Plan One
1501 Dayton Court NE
Renton, WA 98056
(206) 612-8511

RE: Permit Number-Intake 2
2101-001-Intake 2

INTAKE COMMENTS RESPONSE

SHEET  
**S-8**  
 OF  
 -  
 JOB #

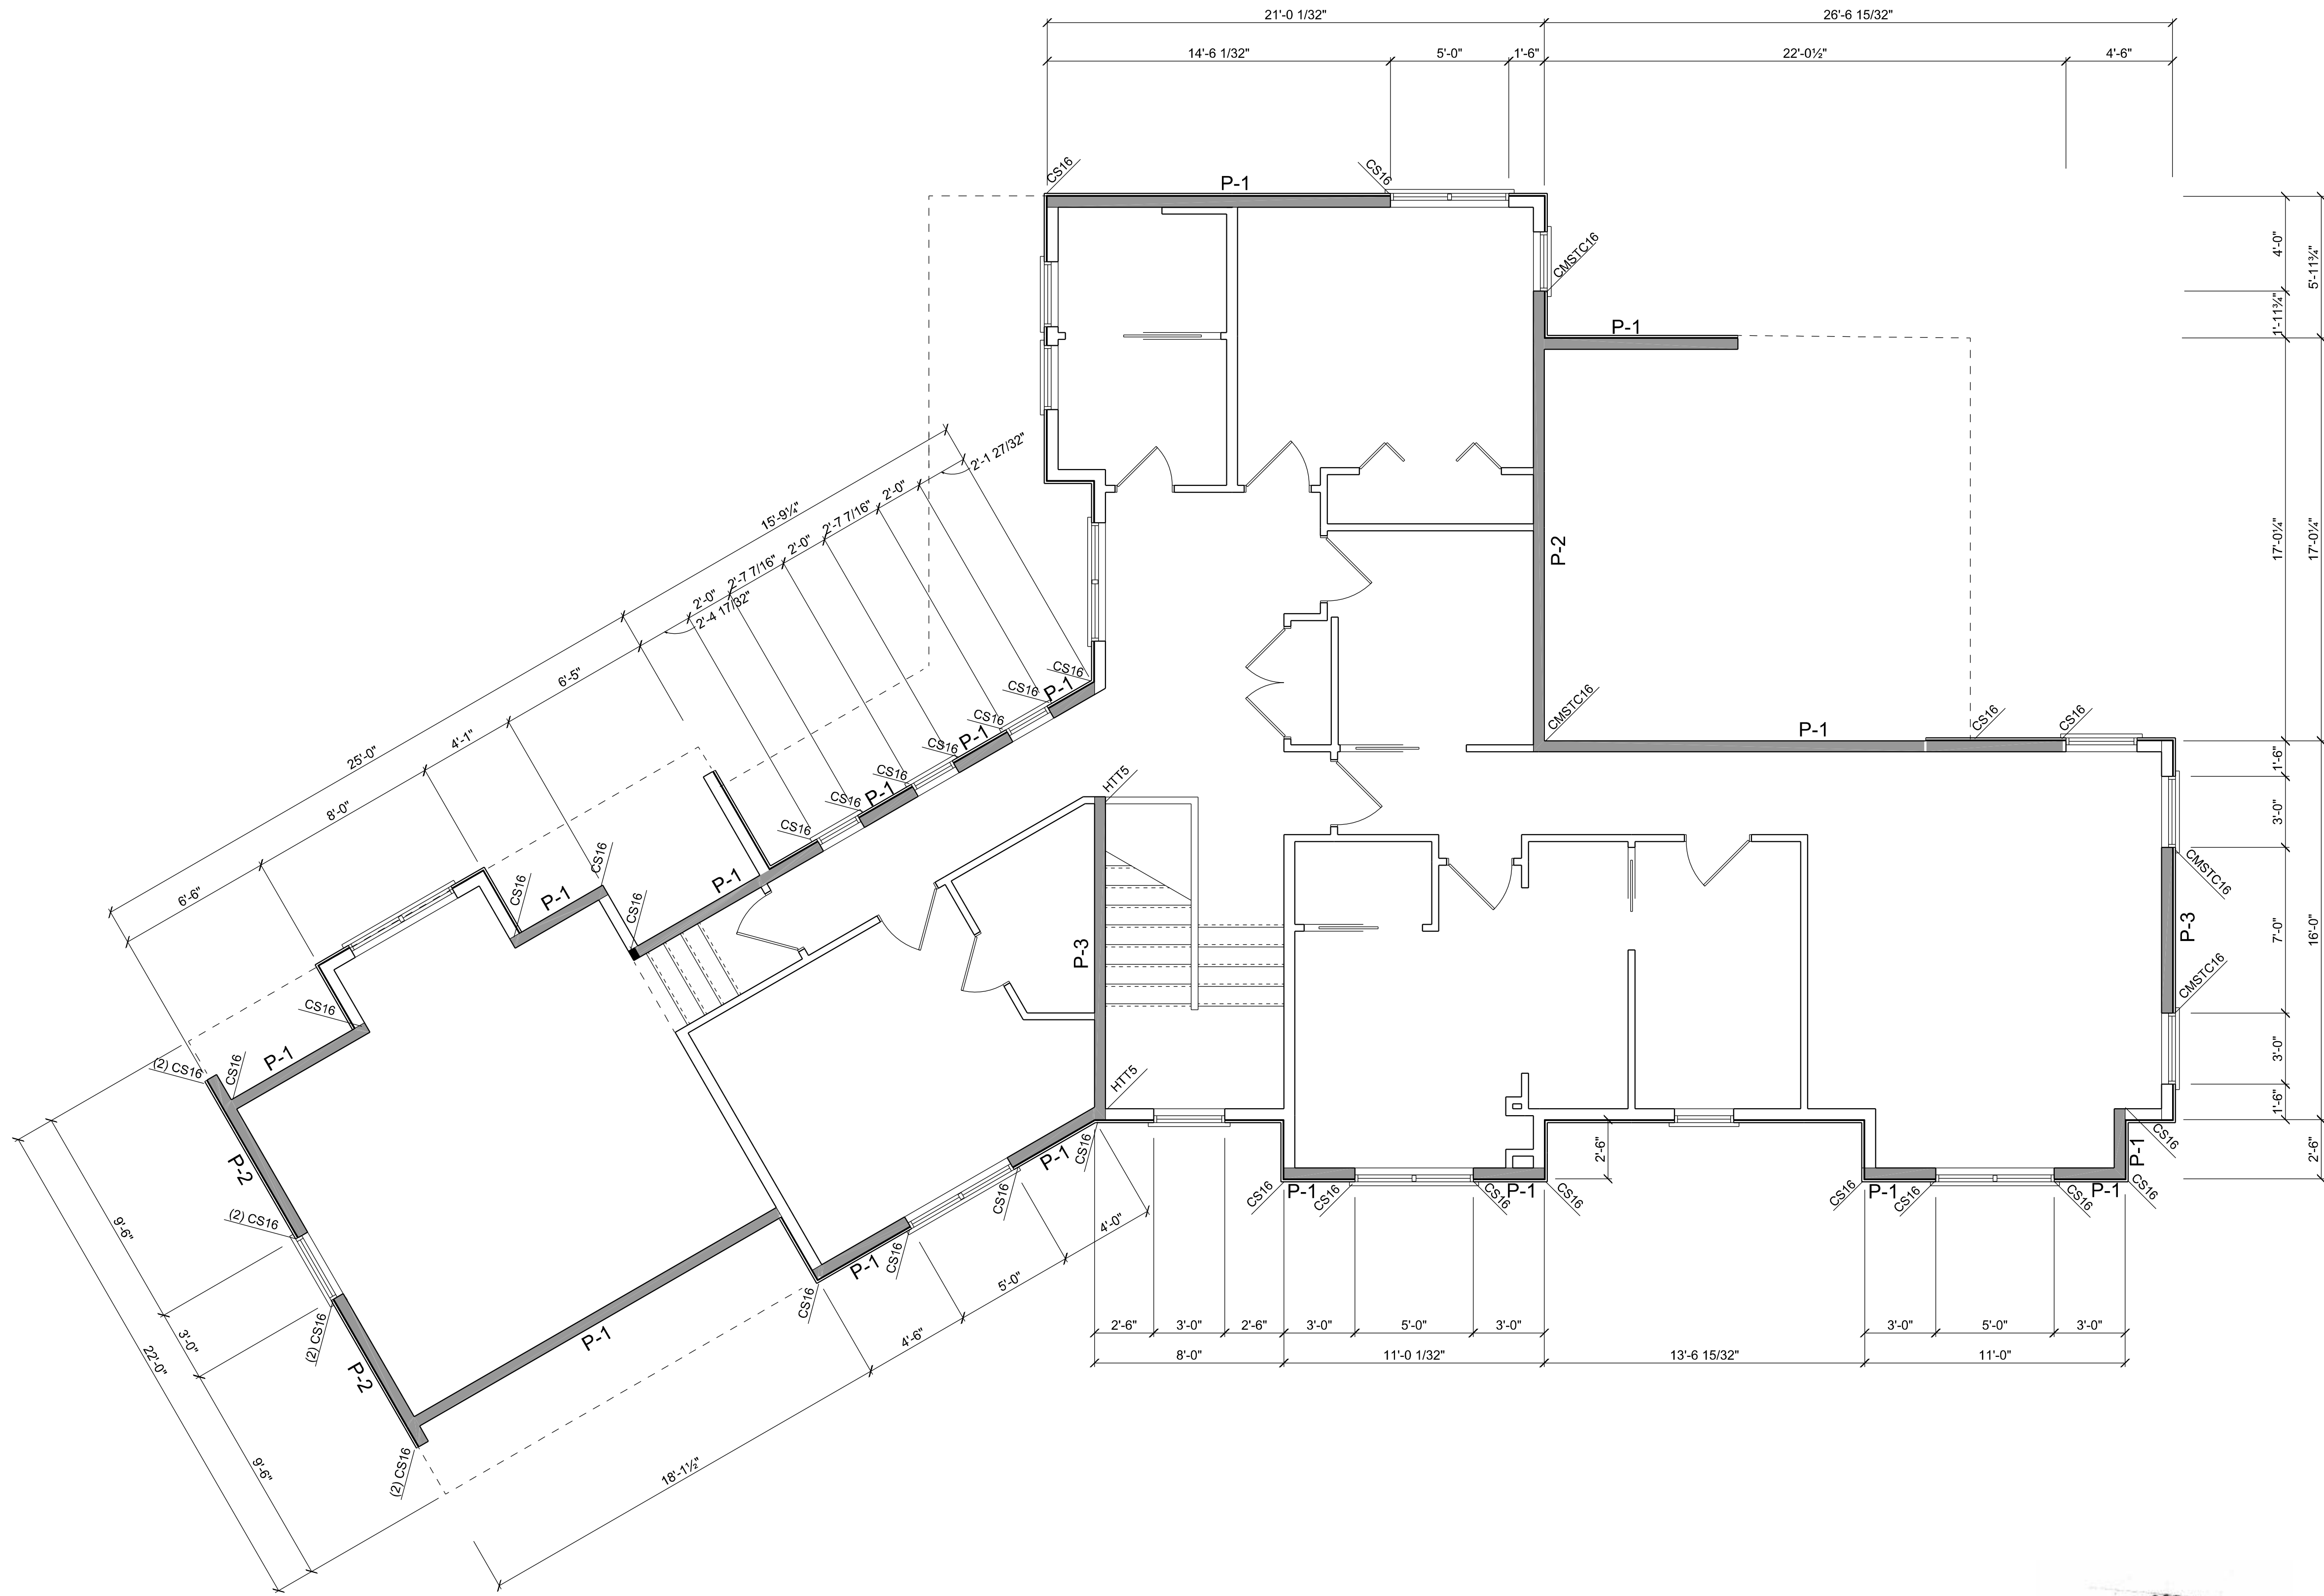
Structural Calculations & Methodology: Shear Wall Plans were provided with the original submittal, Sheets S-7 & S-8.
